Project Special Provisions

Signals and Intelligent Transportation Systems

Prepared By: _____
30-Sep-09

LOOP WIRE TWISTING METHOD

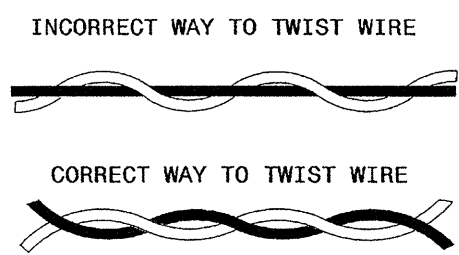
1.4. Inductive Detection Loops – Construction Methods (1725-3)

Page 17-20, Subarticle 1725-3, In the first paragraph, revise the first sentence to:

“Between where loop conductor pairs leave saw cut in pavement and junction boxes, twist loop conductor pairs a minimum of 5 turns per foot.”
